Wendlebury Road, Bicester
Stage 1 Road Safety Audit

10 March 2020

We have pleasure in enclosing a copy of the Stage 1 Road Safety Audit report (Doc. Ref: 414124/TPN/ITD/015/B 10 March 2020) for the above mentioned scheme.

JOB TITLE CATALYST BICESTER		CLIENT ALBION LAND	
DRAWING TITLE WENDLEBURY ROAD SITE ACCESS ROUNDABOUT			
SCALE 1: 500@A1	DRAWN BY RJM	DATE 03/05/19	DRAWING No 19539-12-02
REVISION B

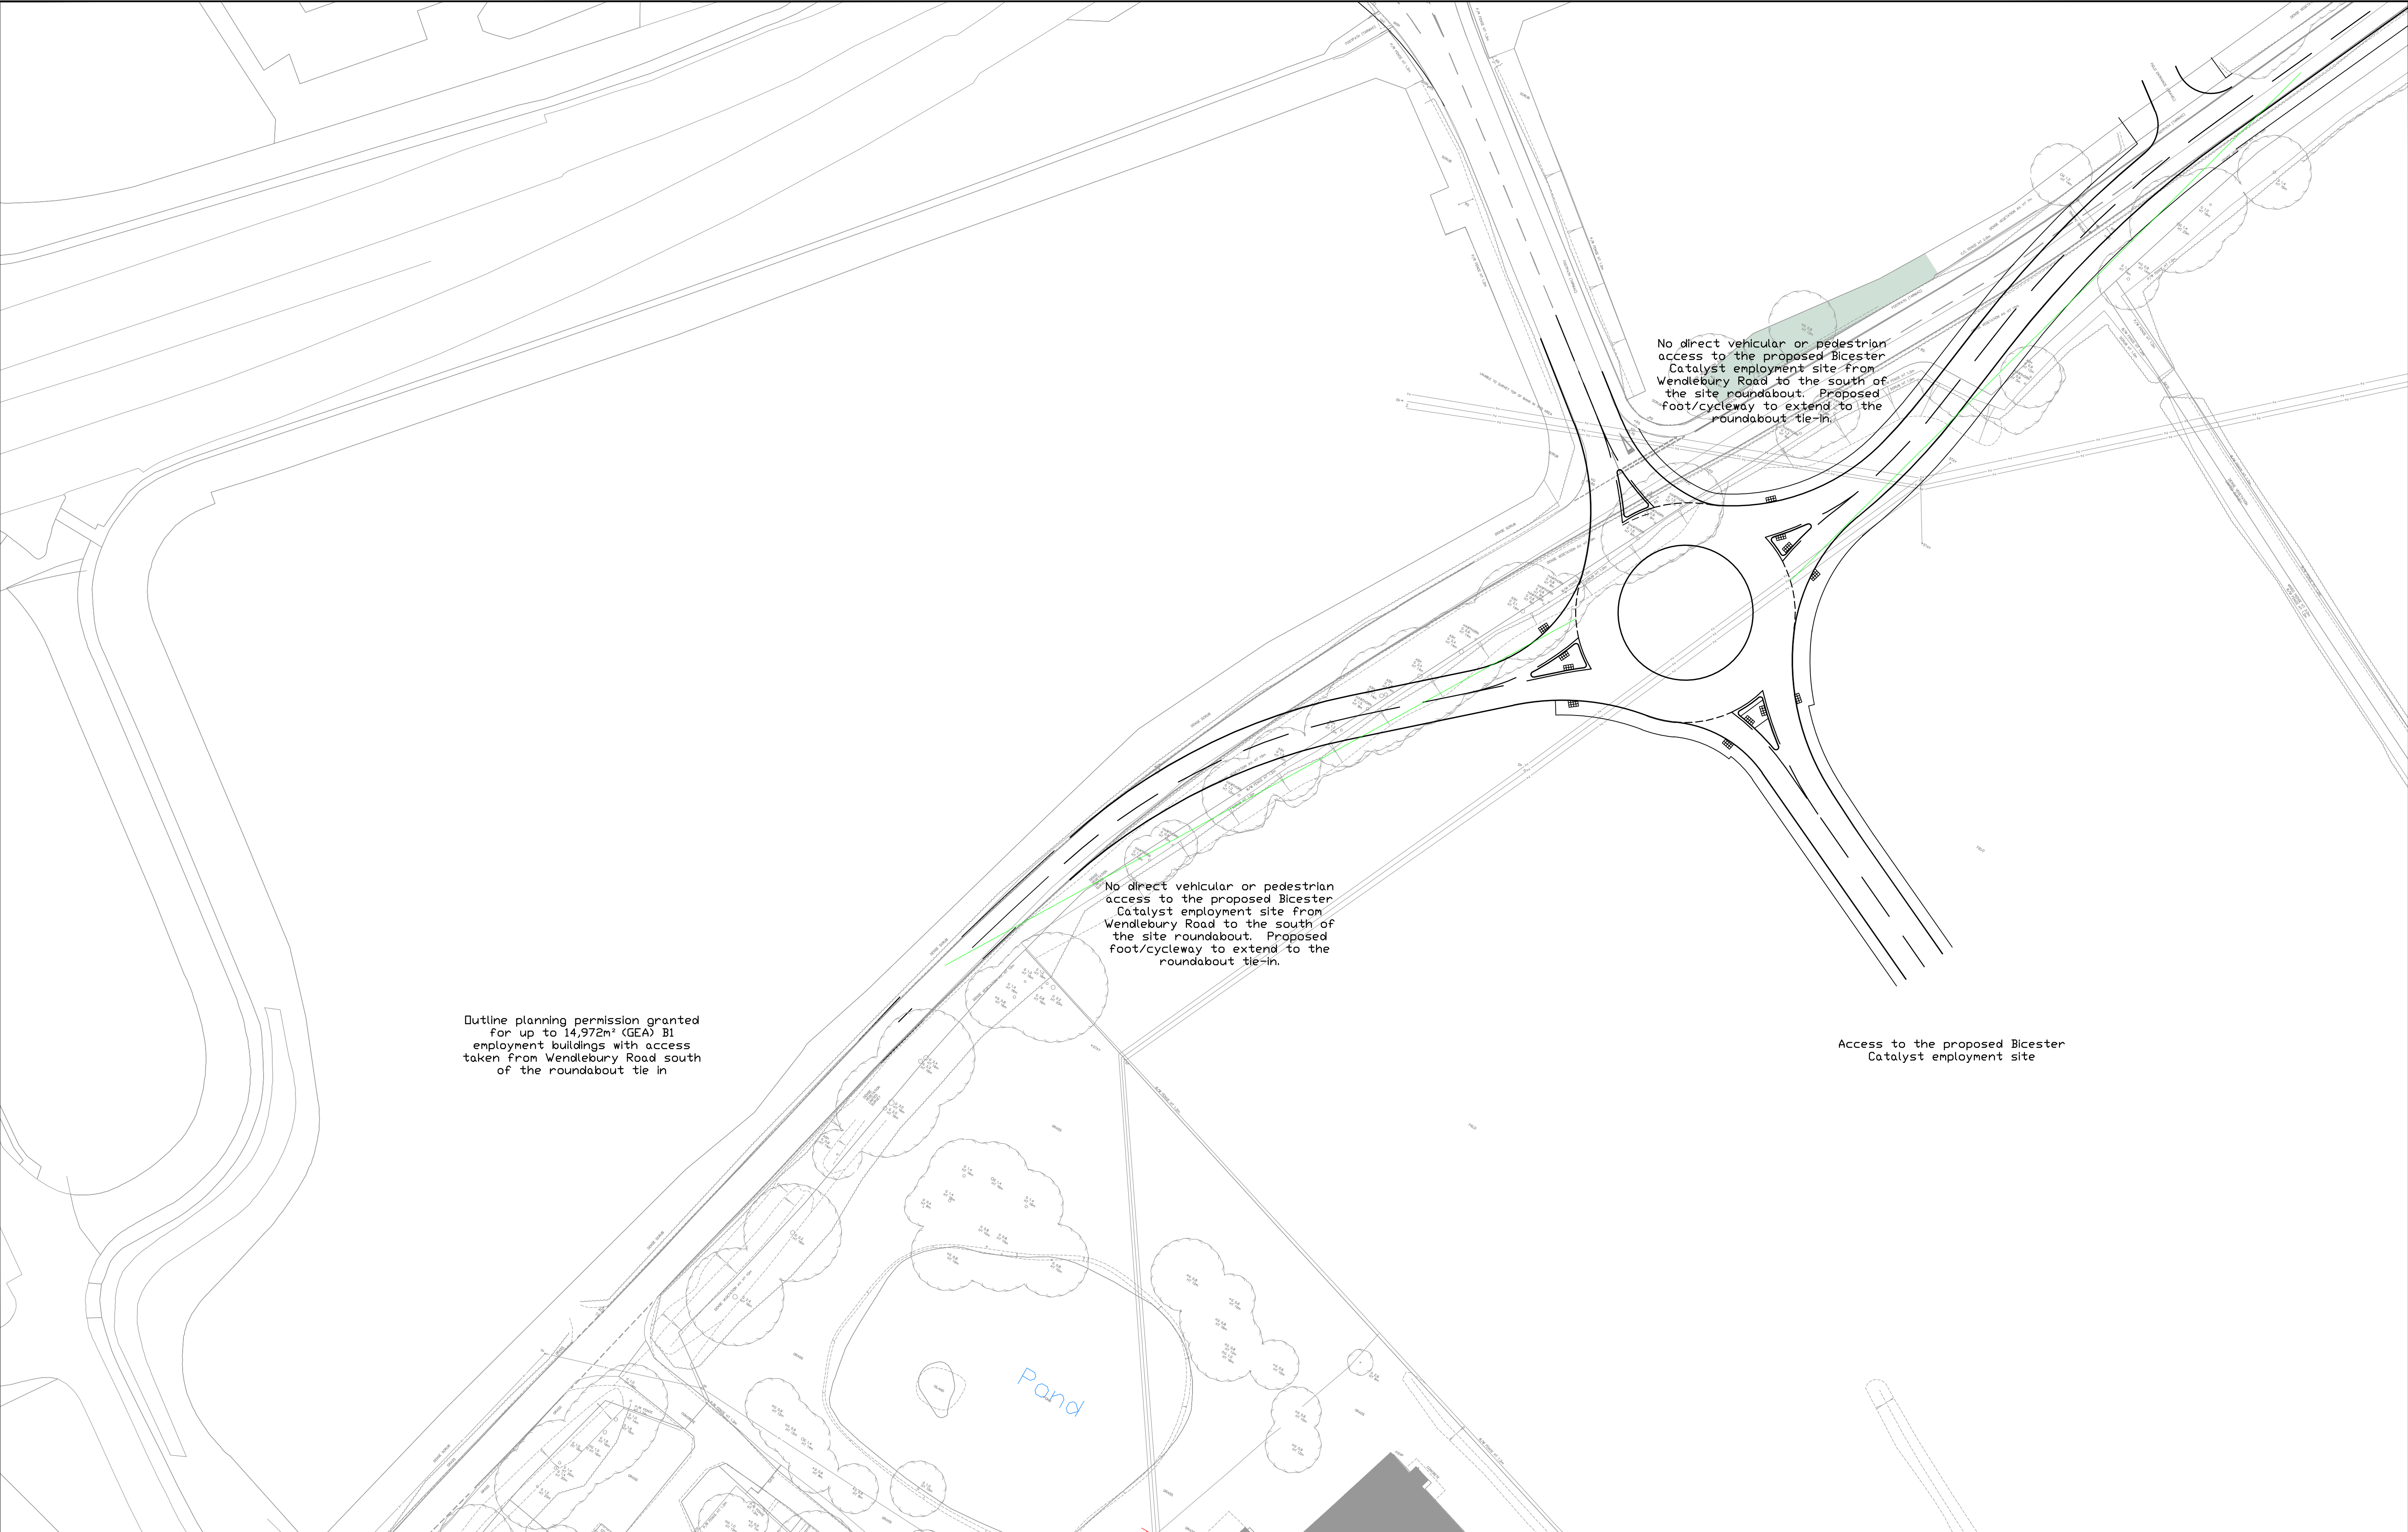
In addition to the completion of a Road Safety Audit, as requested the Audit Team has also given consideration to the Local Highway Authority's request for a 'Dutch' style roundabout that includes cycle priority crossings on all arms.

Whilst such roundabouts are considered to have a good safety record in the Netherlands, they are an established form of provision in a country that has a greater proportion of cyclists. The cycle modal share in the Netherlands is approximately 27% compared to the UK's 2% (Wikipedia, 2020). It should also be noted that the UK does not currently have any other examples of such roundabouts, with the first currently under construction in Cambridge. As such, motorists and cyclists are likely to be unfamiliar with such a highway arrangement. This may potentially lead to uncertainty and hesitancy. This may increase the risk of rear end such type collisions on the roundabout circulatory carriageway, or a greater incidence of motorists failing to give way to cyclists.

Should such a roundabout be provided, it would need to be viewed as an 'experimental' or 'trial' installation and carefully monitored by the Highway Authority. Furthermore, careful signing and public awareness campaigns would also be necessary. This is supported by a research paper produced by TRL in 2015 for Transport for London (*Off street trials of a Dutch-style roundabout Cycle Facility Trials, Work Stream 2: Off-street trials of the safety implications of a Dutch-style roundabout with orbital cycle track*) which concludes that *'Any [on-street] trial should be accompanied by extensive publicity, including temporary road signs, and public information work, to maximise the chances that a given road user will know what to expect of the infrastructure in terms of priorities.'*

This research paper also recommends conducting *'initial on-street trials at locations where traffic flows are comparatively low (especially of HGVs) and cycle and pedestrian flows are comparatively high, so that drivers expect their presence'*. Given the relatively low pedestrian and cyclist flows at this location, and the anticipated HGV movements around the roundabout, this is unlikely to be an appropriate location to trial a 'Dutch' style roundabout in Oxfordshire.
